From: David Senus <dsenus@woodardcurran.com>
To: Jean Fraser <JF@portlandmaine.gov>
CC: Barbara Barhydt <BAB@portlandmaine.gov>, Ash Auger <aauger@woodardcurran...>
Date: 12/21/2015 11:55 AM
Subject: RE: 171 Warren Ave Level 1- adding 5 parking spaces

From: Jean Fraser [mailto:JF@portlandmaine.gov]
Sent: Monday, December 21, 2015 10:31 AM
To: David Margolis-Pineo <DMP@portlandmaine.gov>; Jeff Tarling <JST@portlandmaine.gov>; Errico Thomas <Thomas.Errico@tylin.com>; David Senus <dsenus@woodardcurran.com>
Cc: Barbara Barhydt <BAB@portlandmaine.gov>; Keith Gautreau <KNG@portlandmaine.gov>; Ash Auger <aauger@woodardcurran.com>
Subject: 171 Warren Ave Level 1- adding 5 parking spaces

Drawing Name:
SITE PLAN

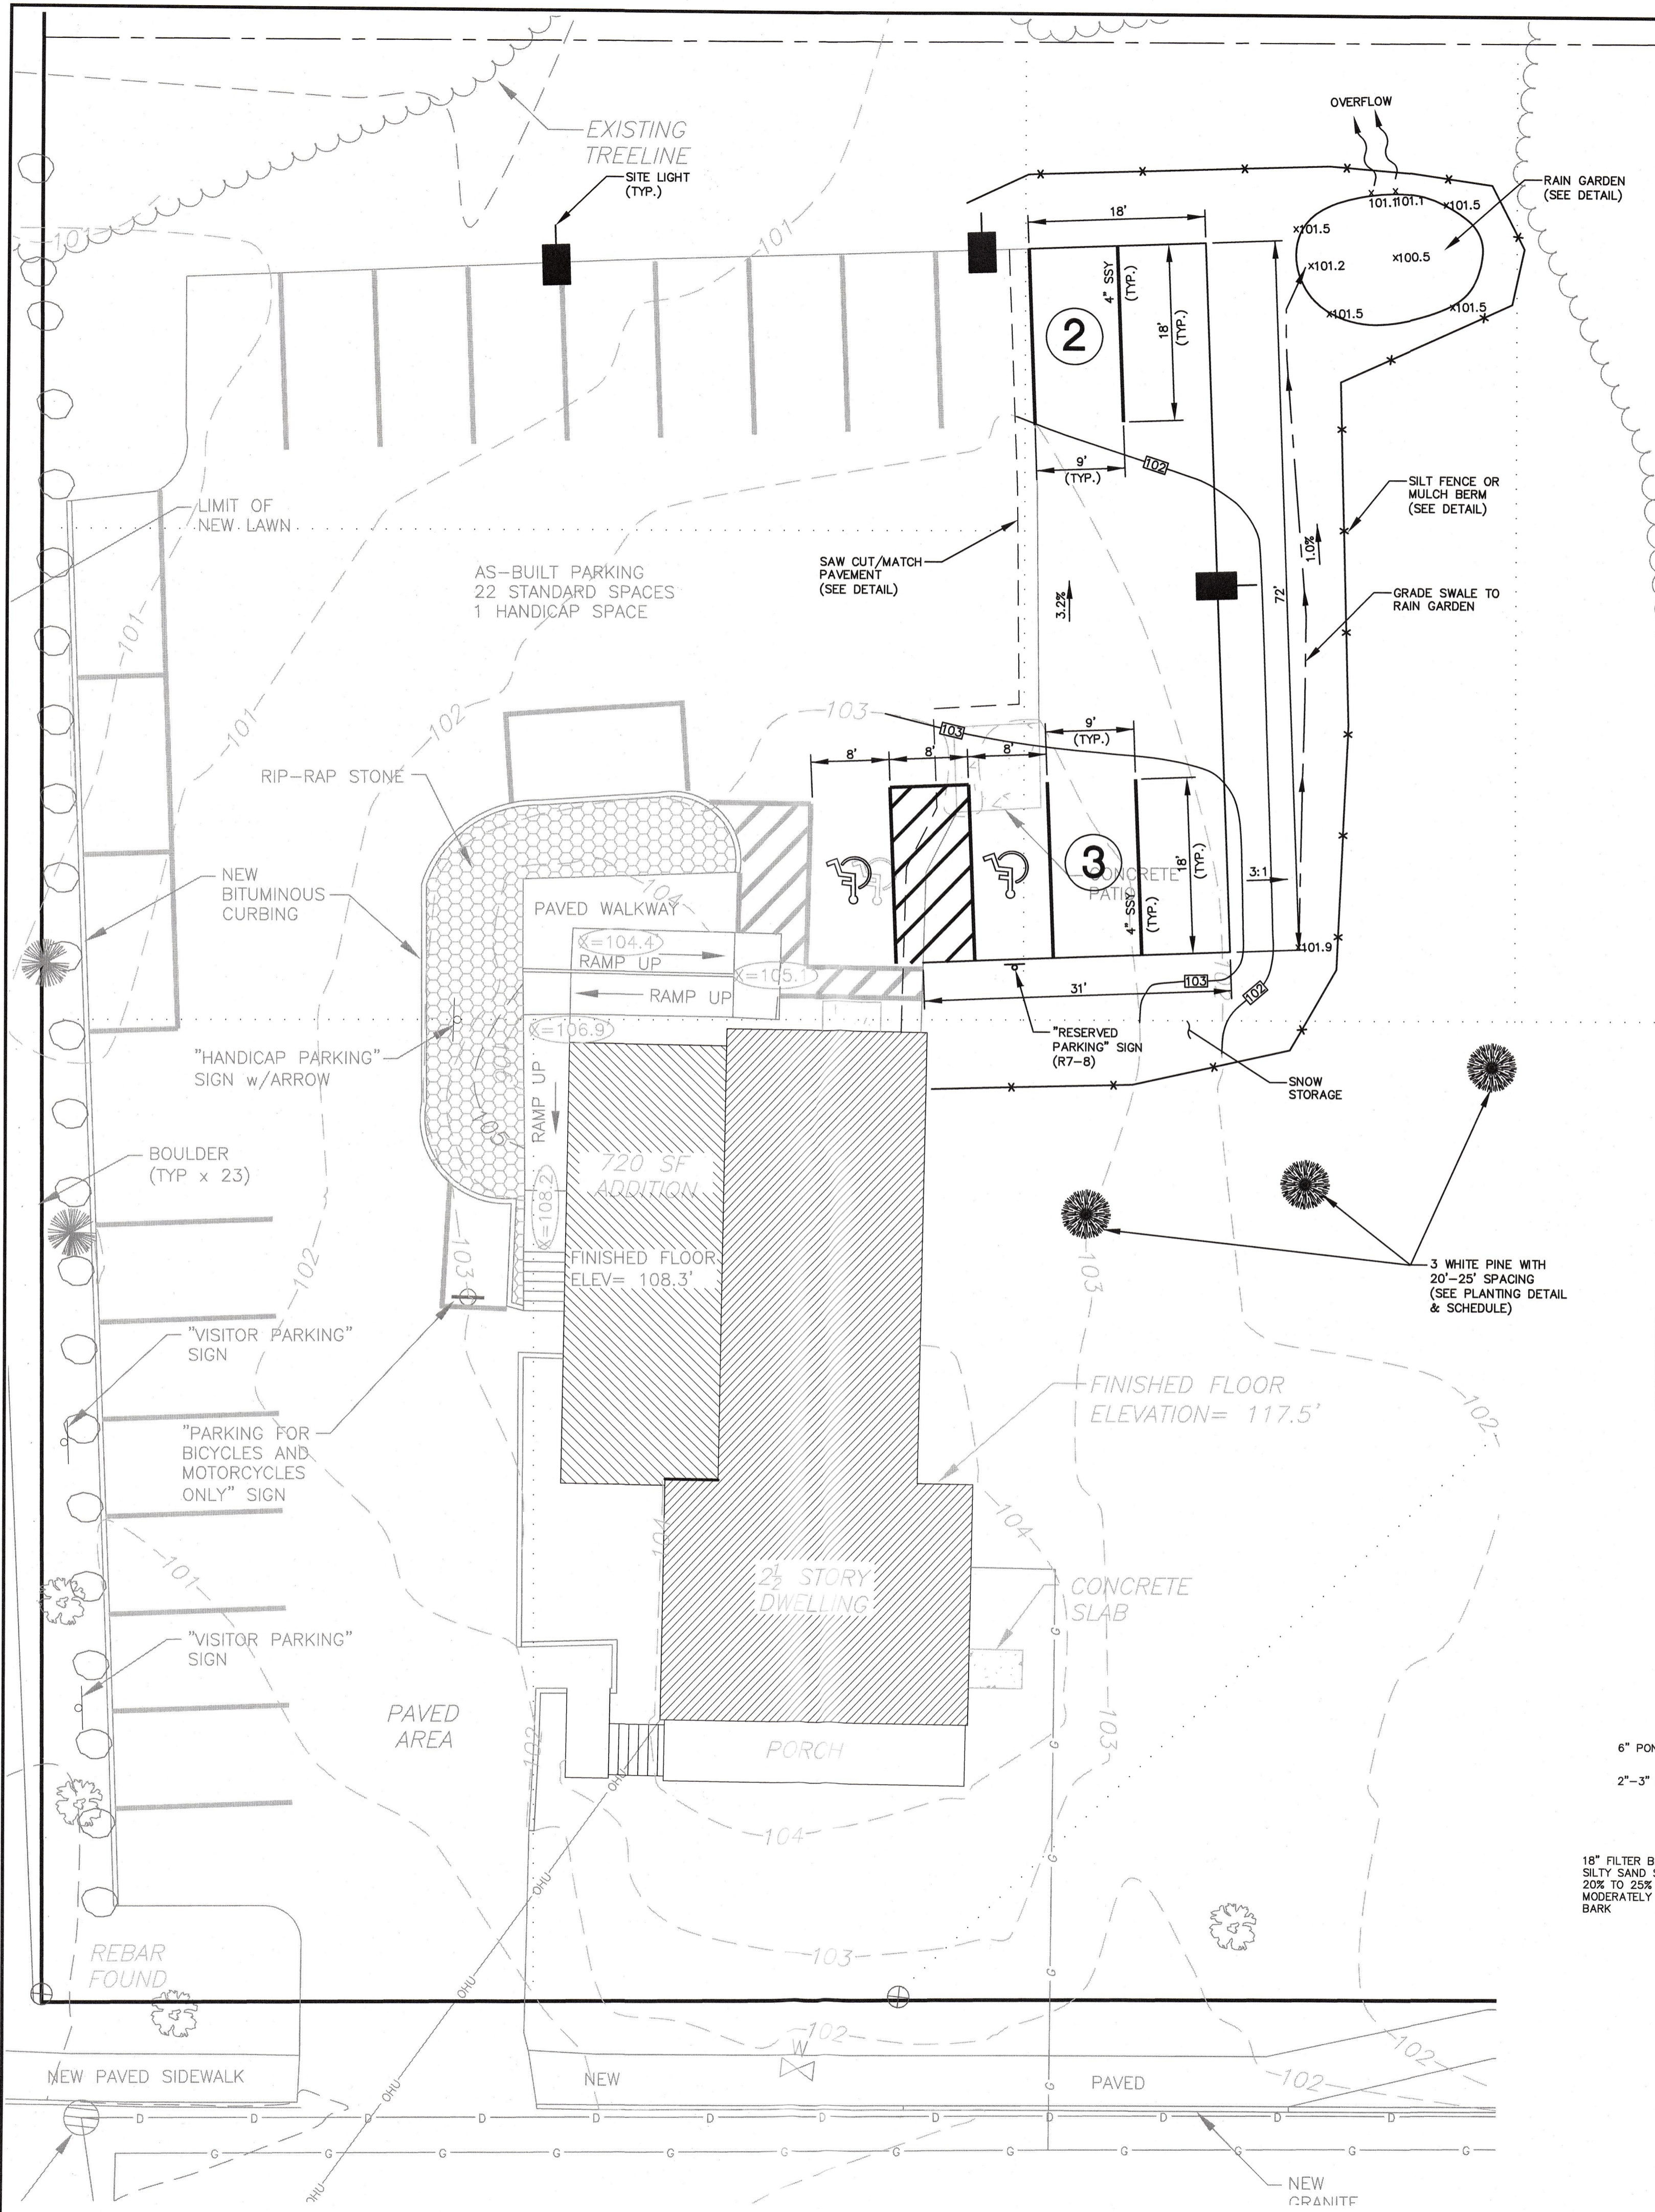
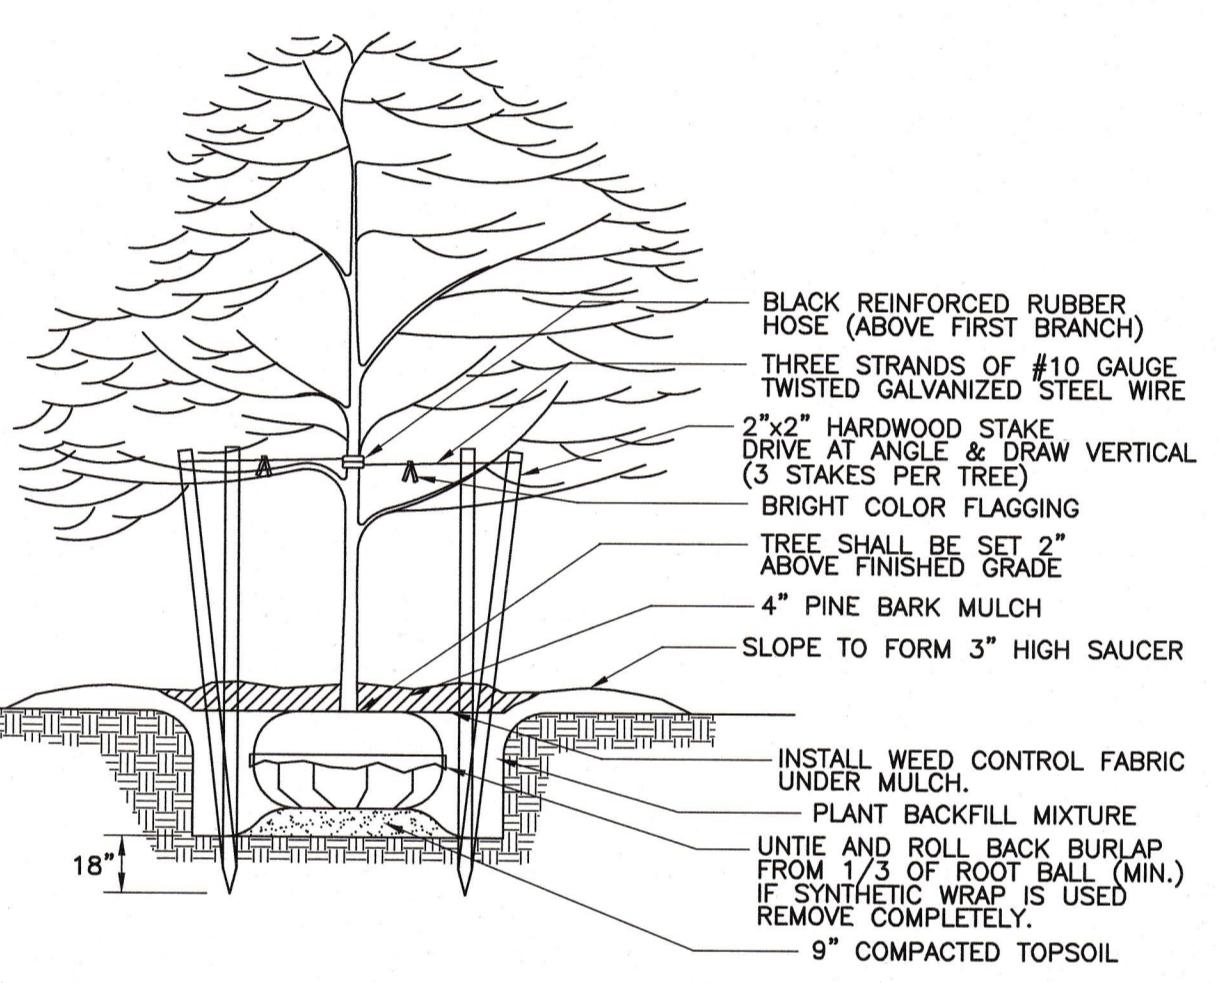
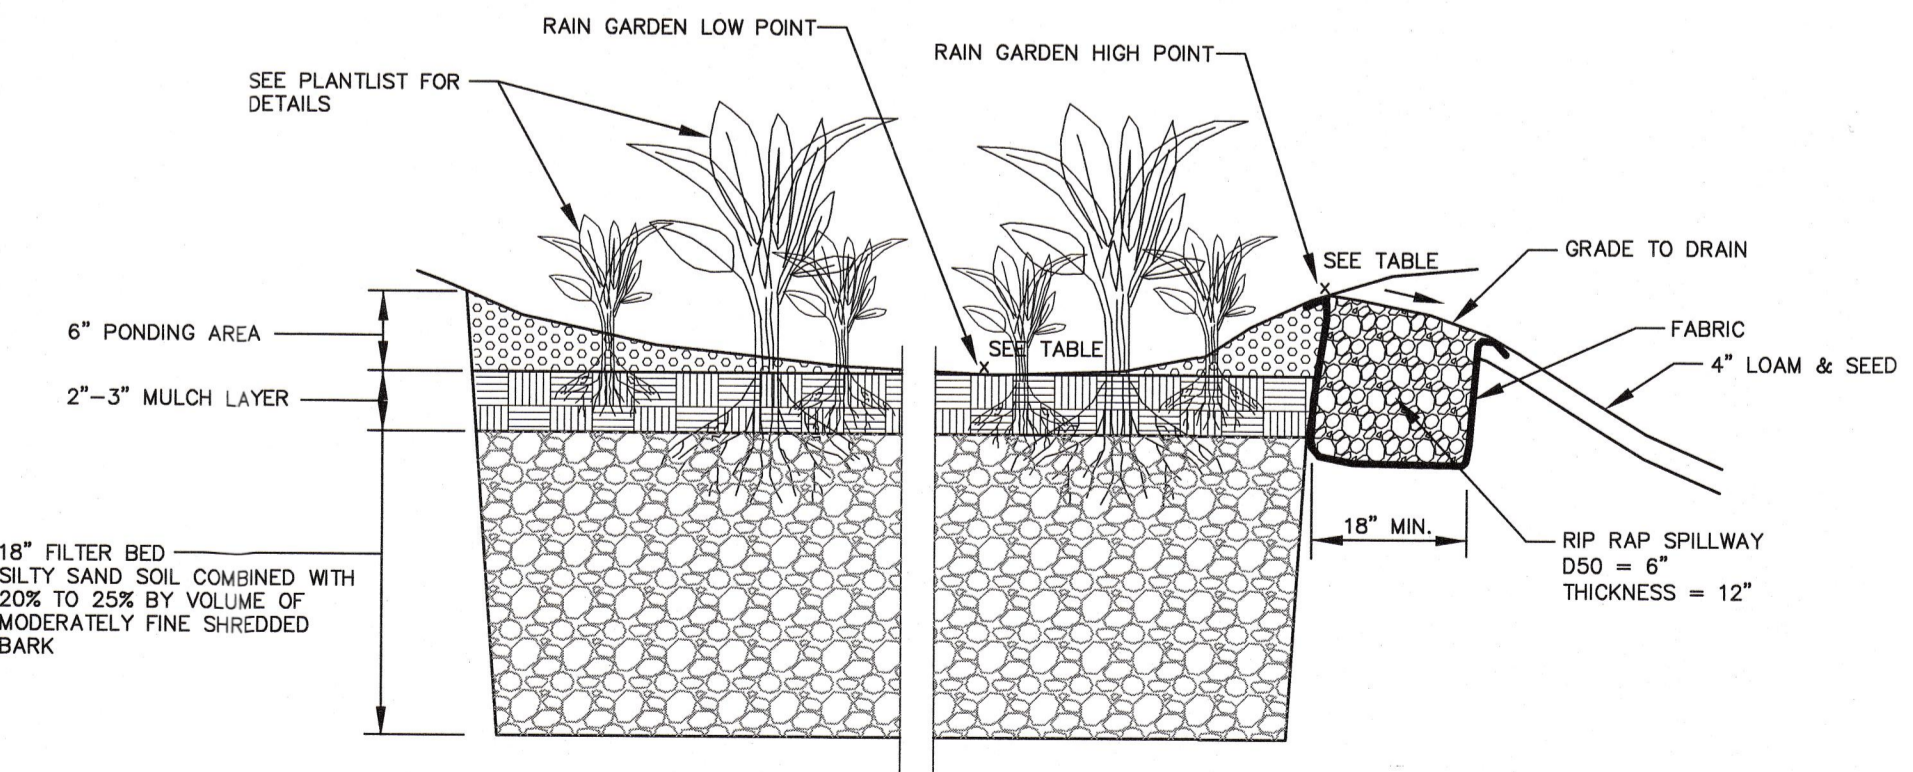
- * stormwater management; (previously no major concerns because of catchbasin in Warren serving main parking area)
- * landscape: at the pre-app stage I advised them to add screening planting but it is not on the site plan; I have asked for this as both zoning and site plan standards apply here;
- * total number of spaces: I don't believe the floorspace shown on the site plan is correct and am getting more info. to see if the minimum parking requirement is exceeded by more than 10%. It is an accountants office so there are employees and members of the public visiting.
